Subject: RE: 23452 Stakers Farm, Yapton - Y/52/22/DOC Designers Response

Further to LLFA Response dated 20 September 2022 for information on the Discharge of Condition application Y/52/22/DOC, we have attached updated drainage drawing 201A_Proposed Drainage Plan together with revised calculations and construction details based on the comments received.

Engineers Comments Regarding Surface Water Drainage

DWG NO.
103

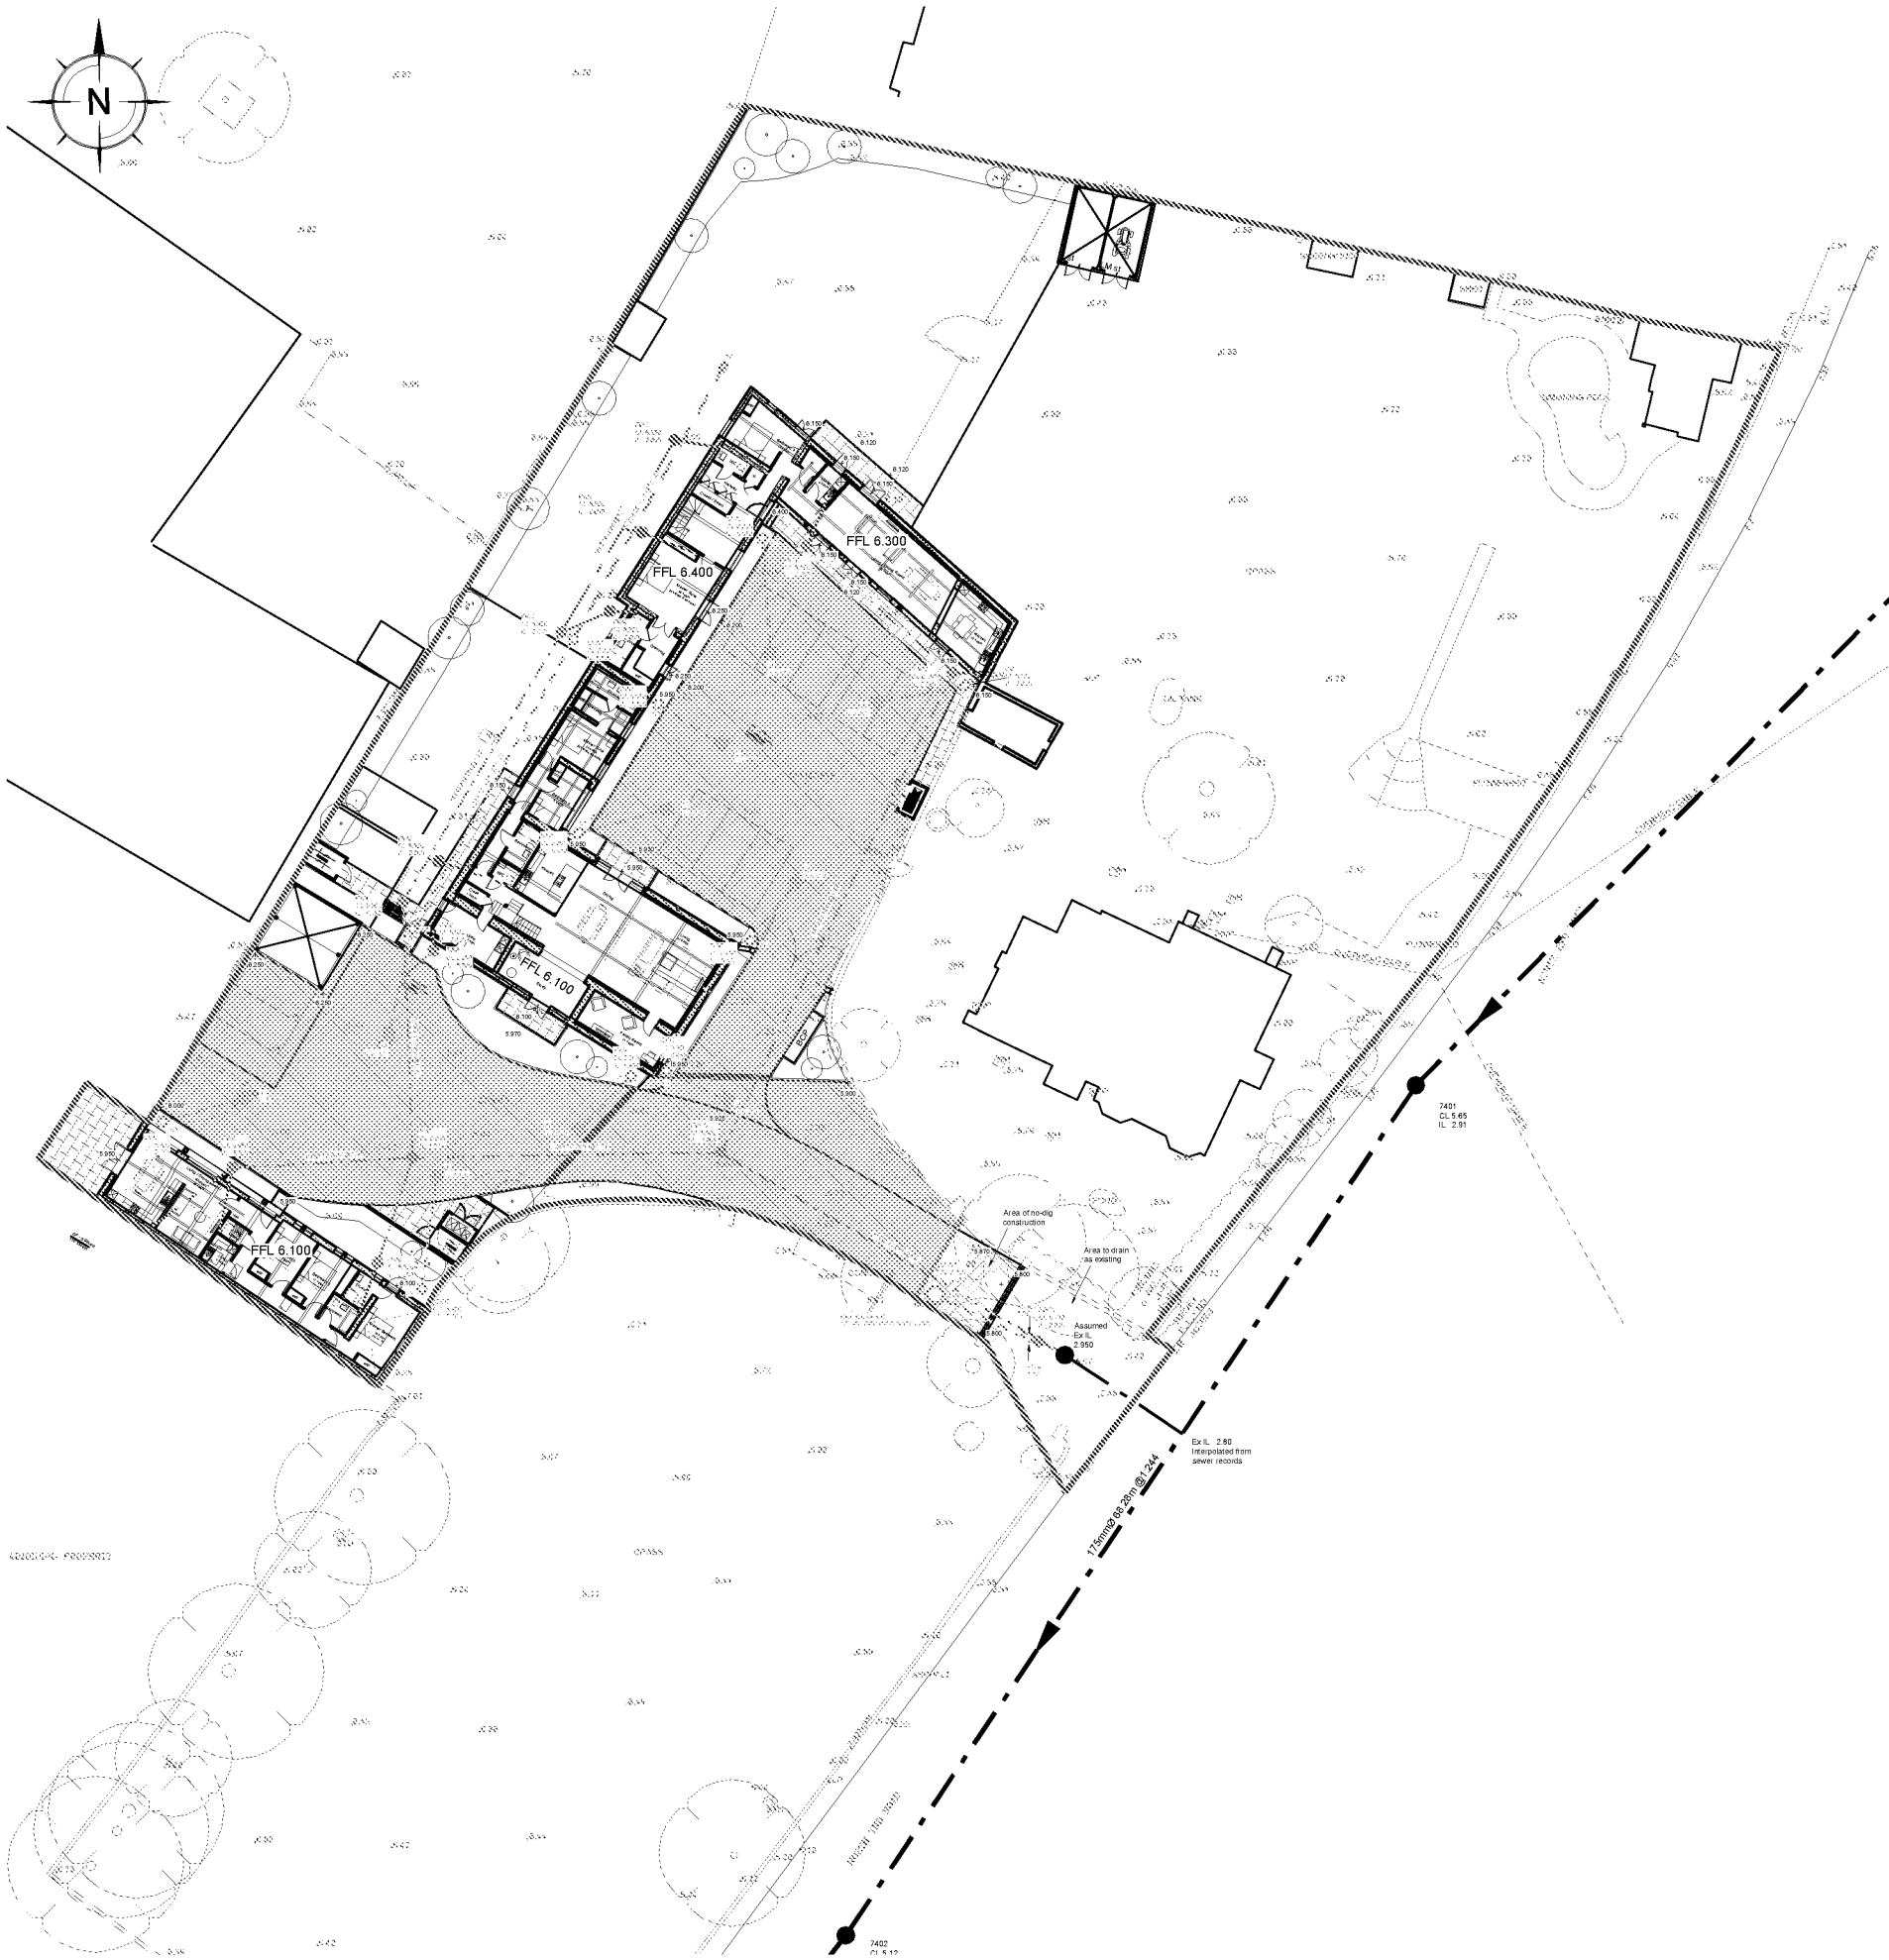
- 6. The drainage calculations should typically include an allowance for urban creep. In this case, we are satisfied that there are limited opportunities for including additional hardstanding, however, the applicant should provide a justification for its exclusion within the report or calculations. 10% Urban creep has been included within the calculations. The impermeable area of the proposed roofs is 715m² and with 10% urban creep of the roofs of 72m², the total area used for the roof is 787m² and the area for the carpark used is 1000m². The total area used for the calculations including the urban creep is 1787 m² or 0.179ha as shown on drawing 103A__Impermeable Areas Plan and the updated calculations.

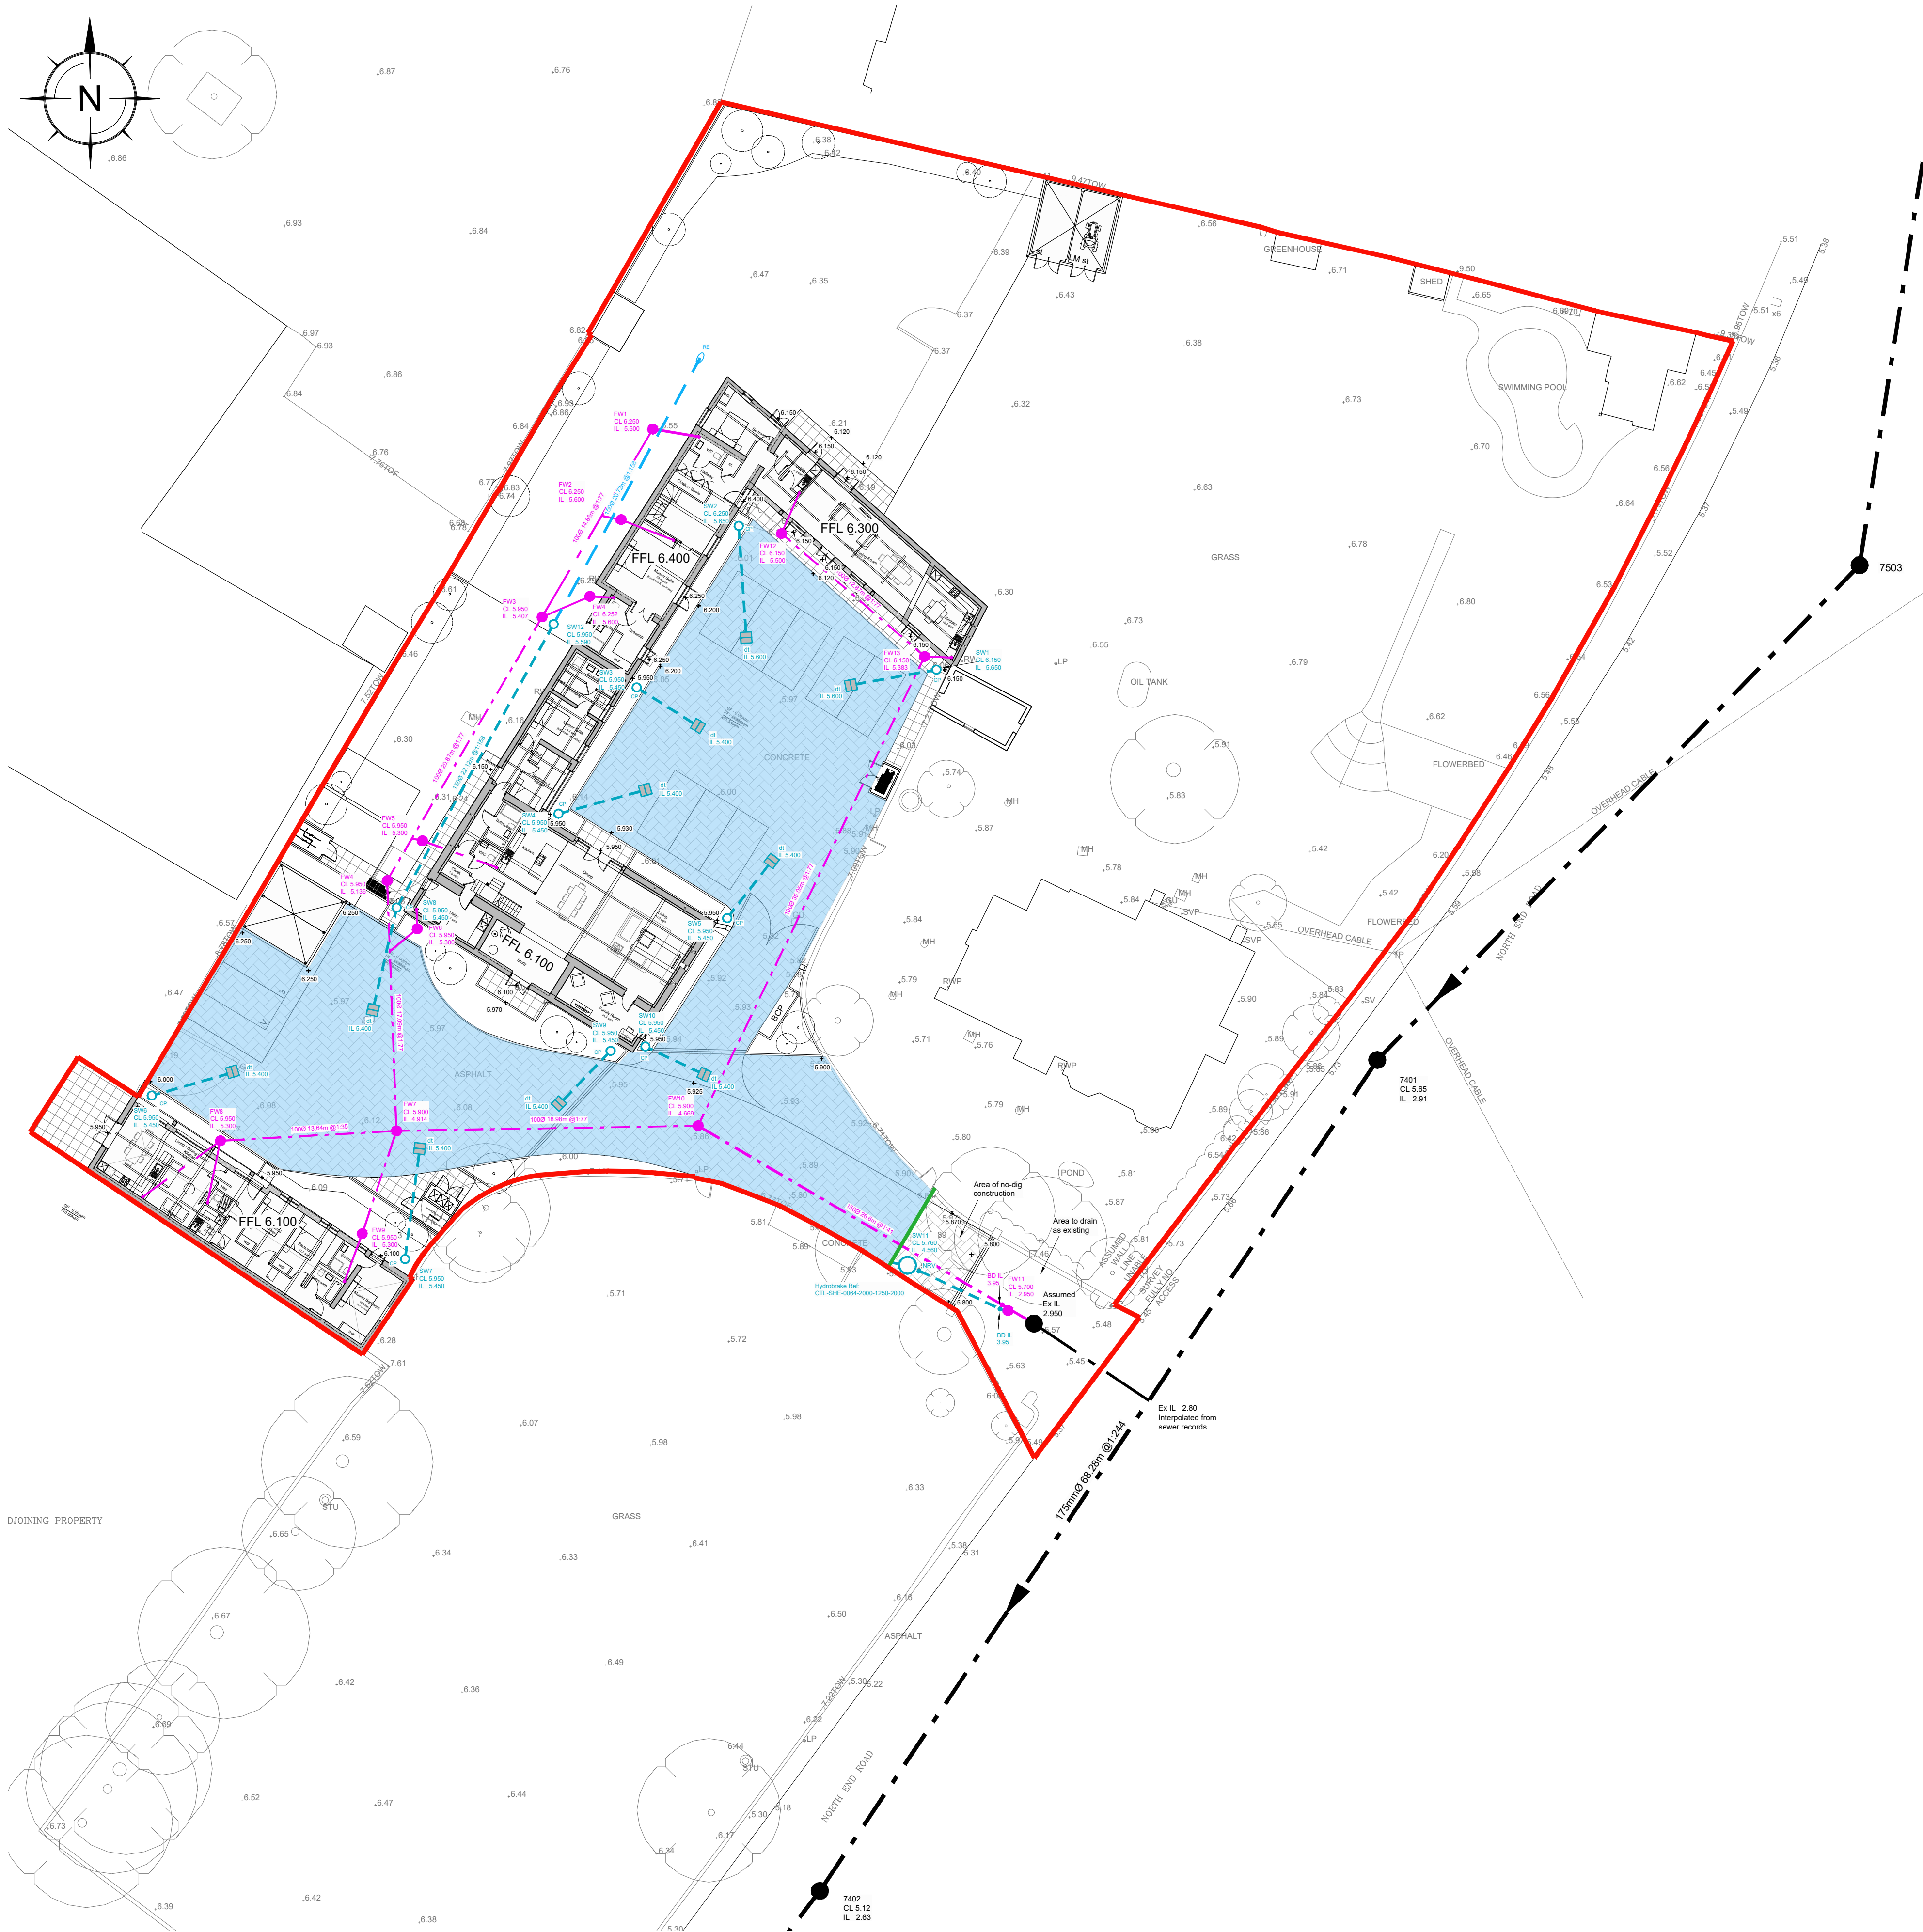
- Service corridors for other services provided to the buildings should be shown, or a statement provided detailing how these will be successfully implemented within the scheme. Service trench corridors have been included within the drainage strategy noted on drawing 201A, copy attached.
